AQUIND INTERCONNECTOR

Consultation Report – Appendix 1.4Z
Statutory Consultation - Feedback from
Marine Stat and Non-Stat S42 Consultees

Document Ref: 5.1.4Z

DATE: 14 NOVEMBER 2019

File name \\UK.WSPGROUP.COM\CENTRAL DATA\PROJECTS\62100XXX\62100616 - AQUIND VO NO.3\IE MODELS AND DRAWINGS\300 - SITE\340 - TASK 9 MARINE ROUTE\CURRENT\ENVIRONMENTAL STATEMENT\UK\REV 1\FIGURE 3.5 UK INDICATIVE SEABED PREP AREA REV1.DWG

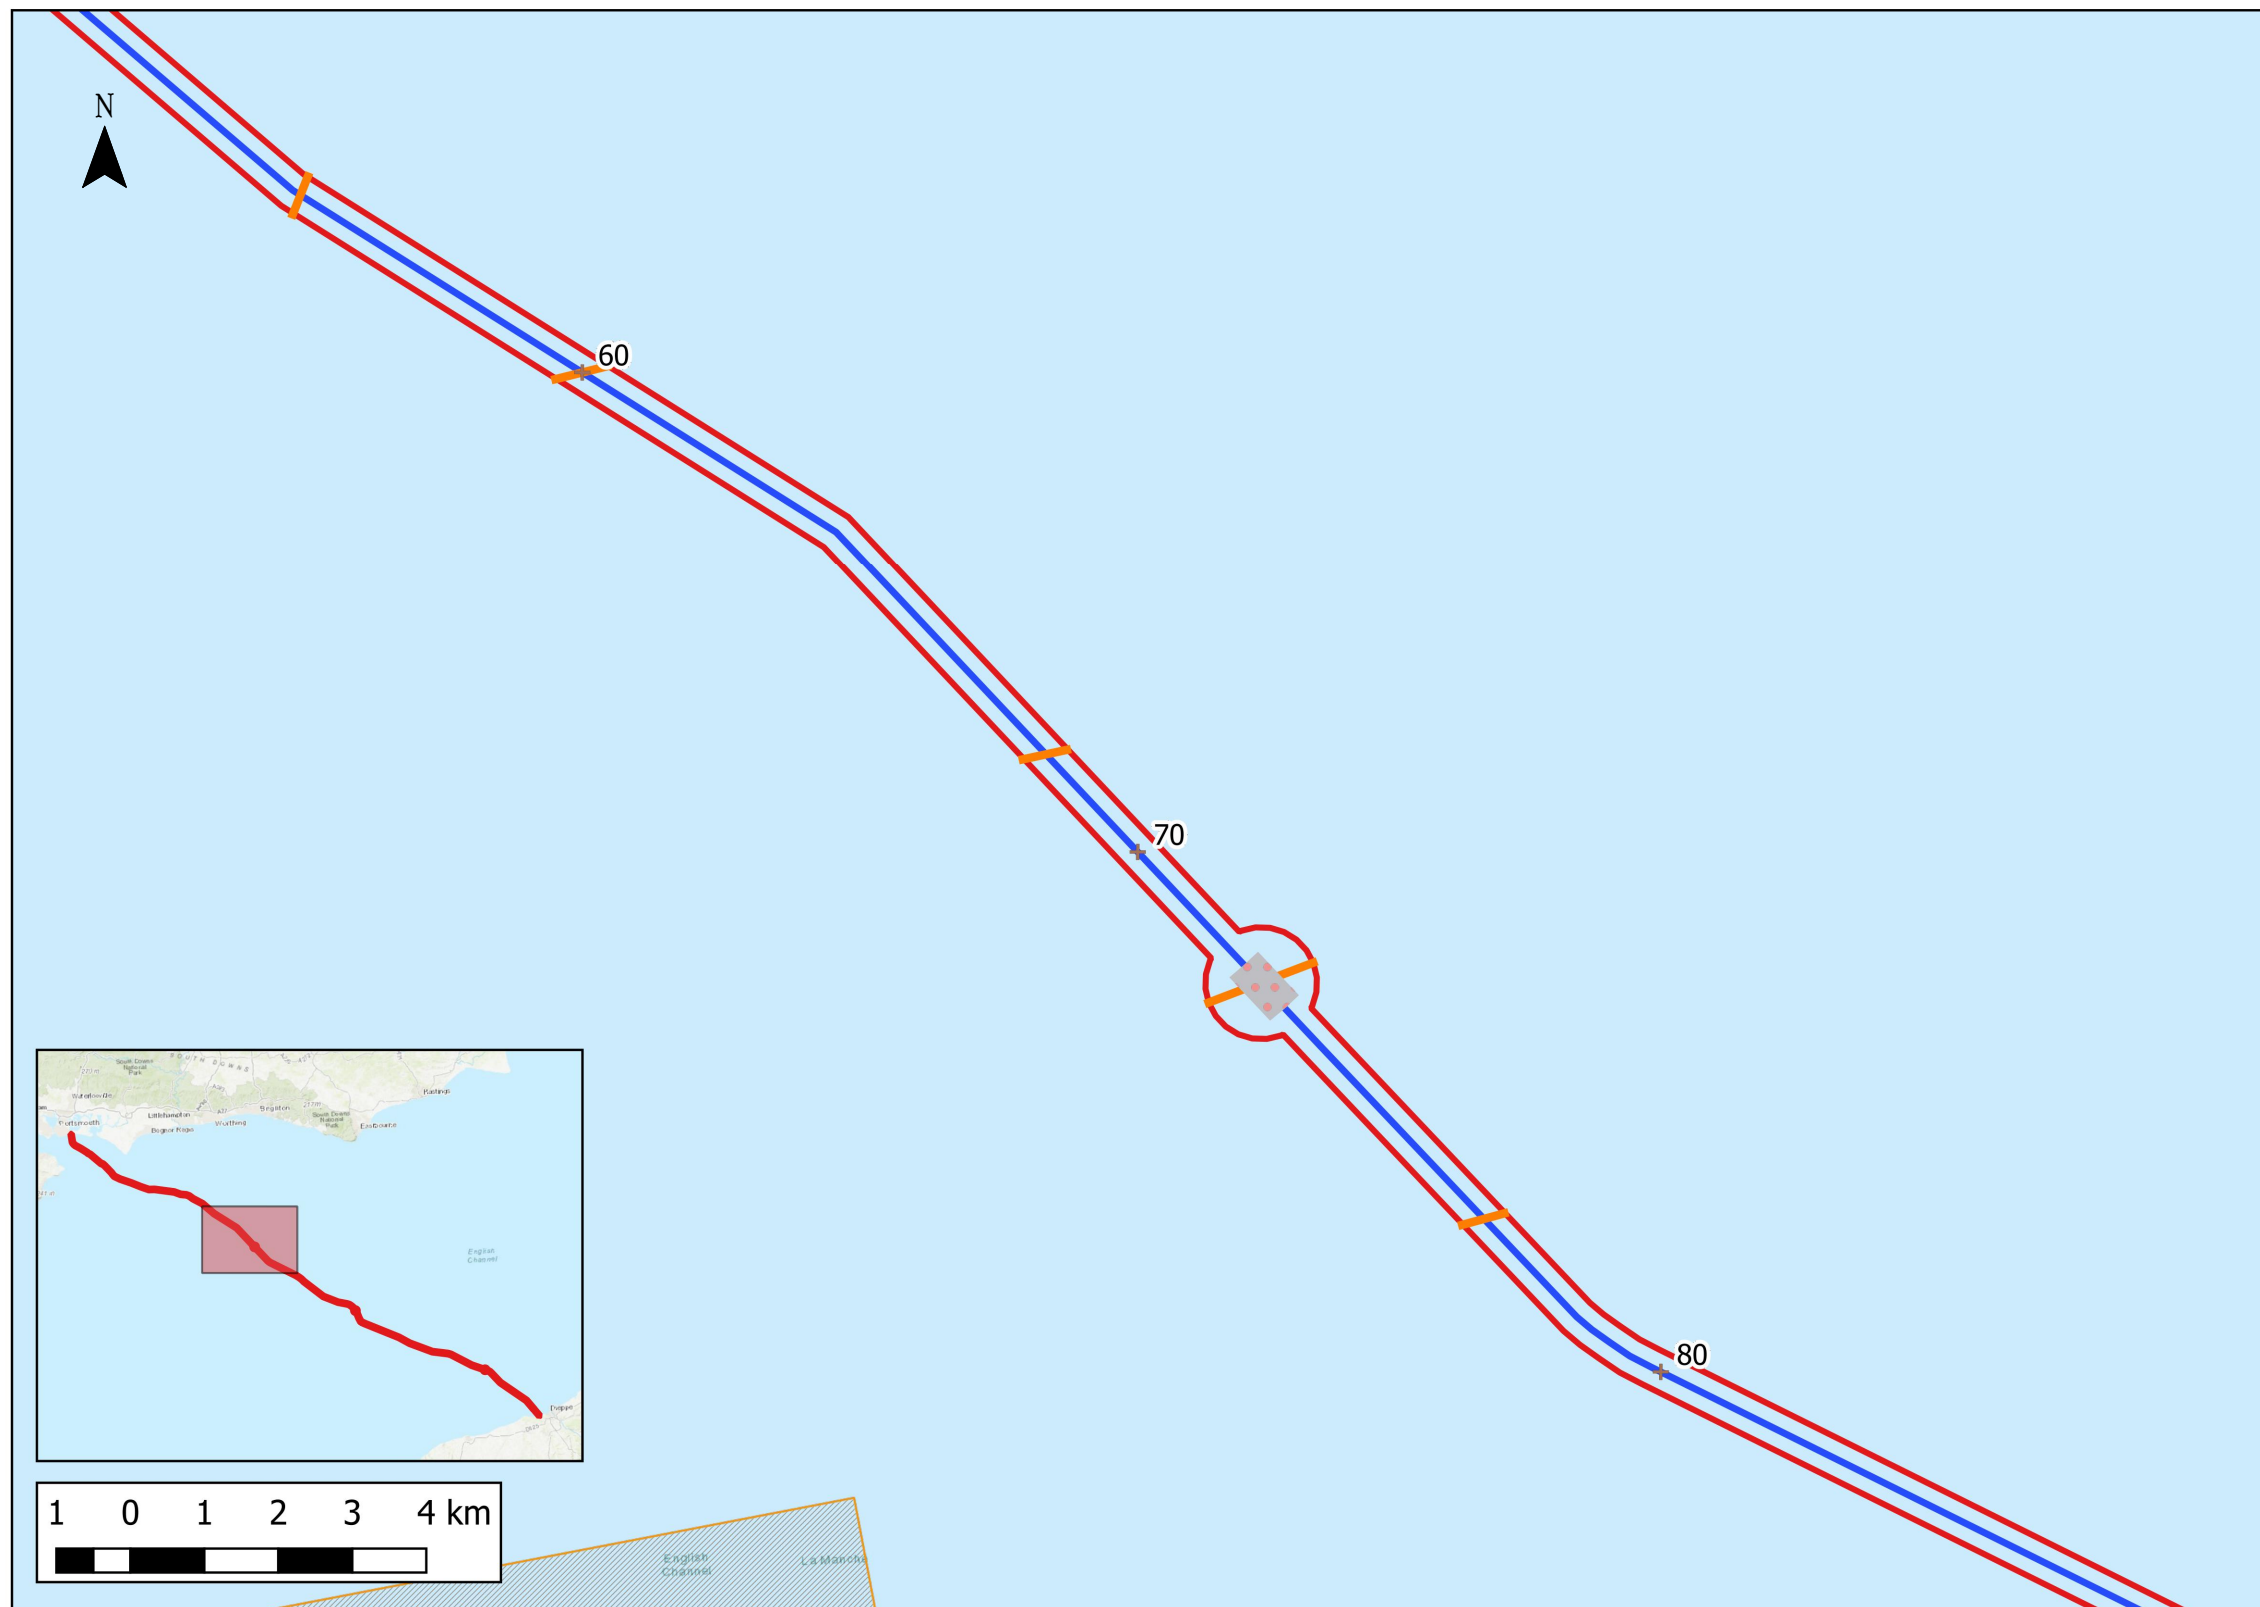
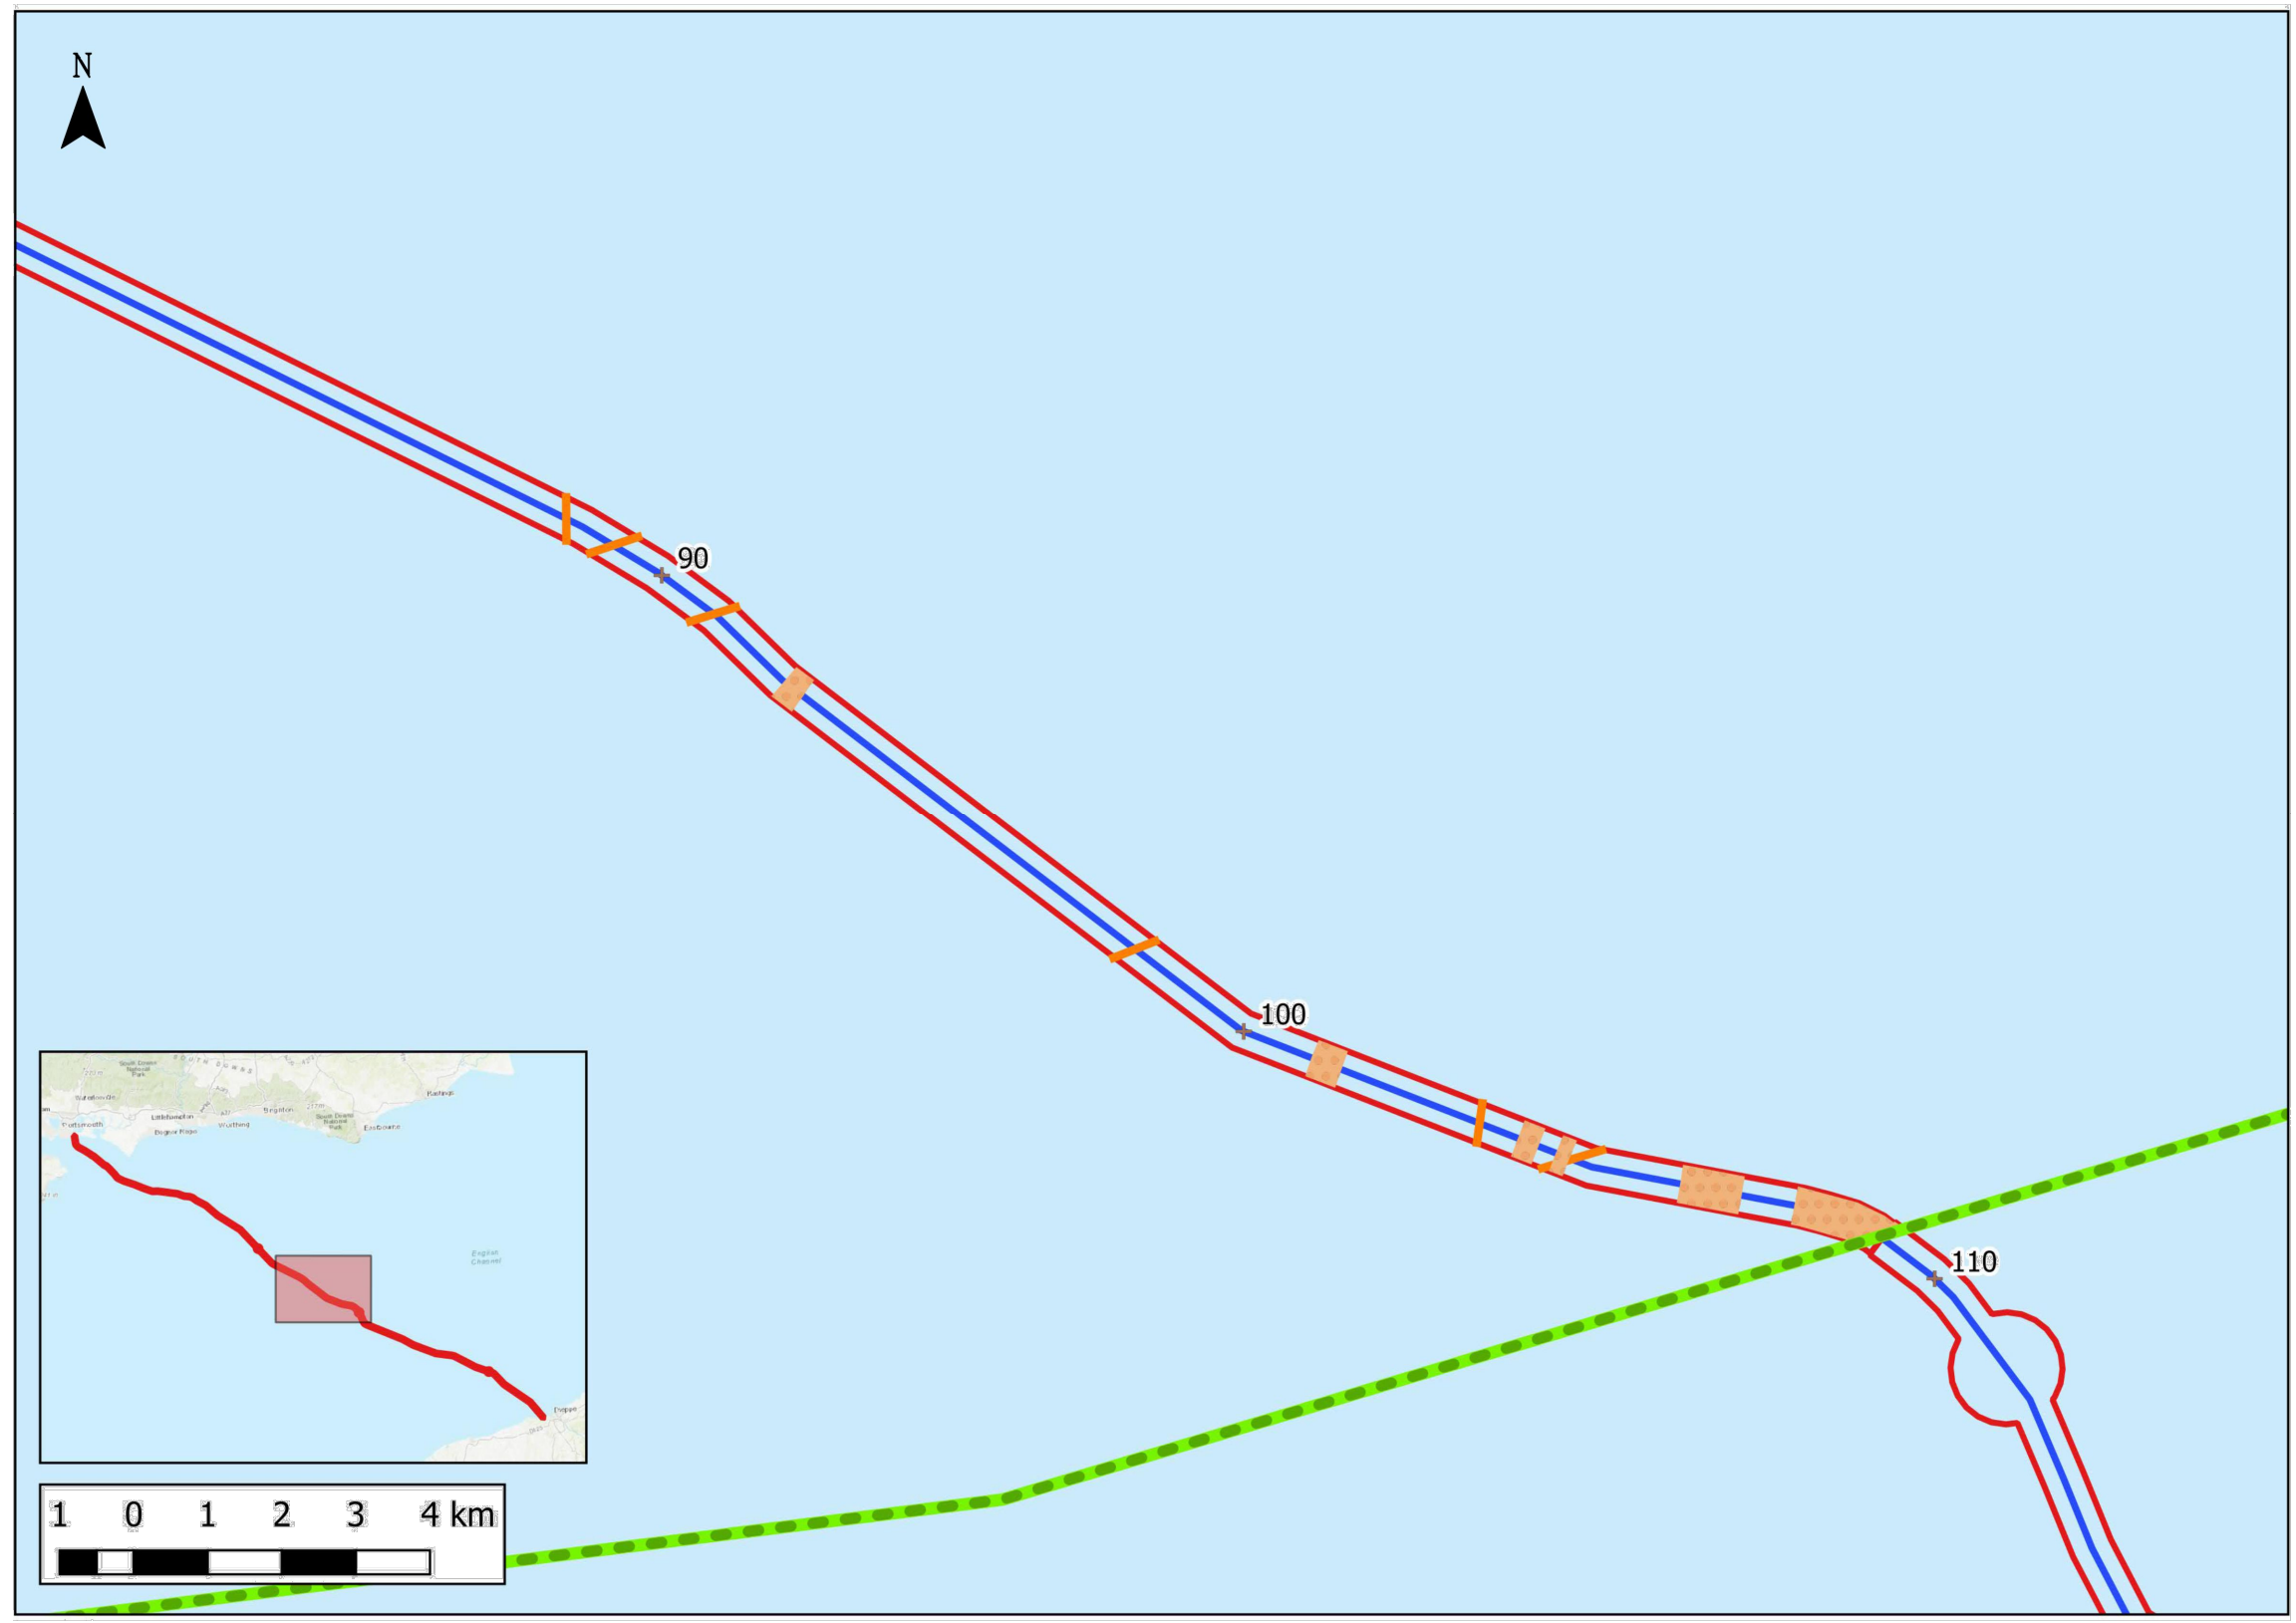
| Item | Topic | Natural England Comment |
|------|--|---|
| 23 | Intertidal and Benthic Ecology | Natural England advises that for the following figures: 3.3 (UK Landfall), 3.6 (UK Mobile Sediment) and 3.5 (Indicative Seabed Preparation), it would be beneficial to display nationally and international designated conservation sites for ease of reference. |
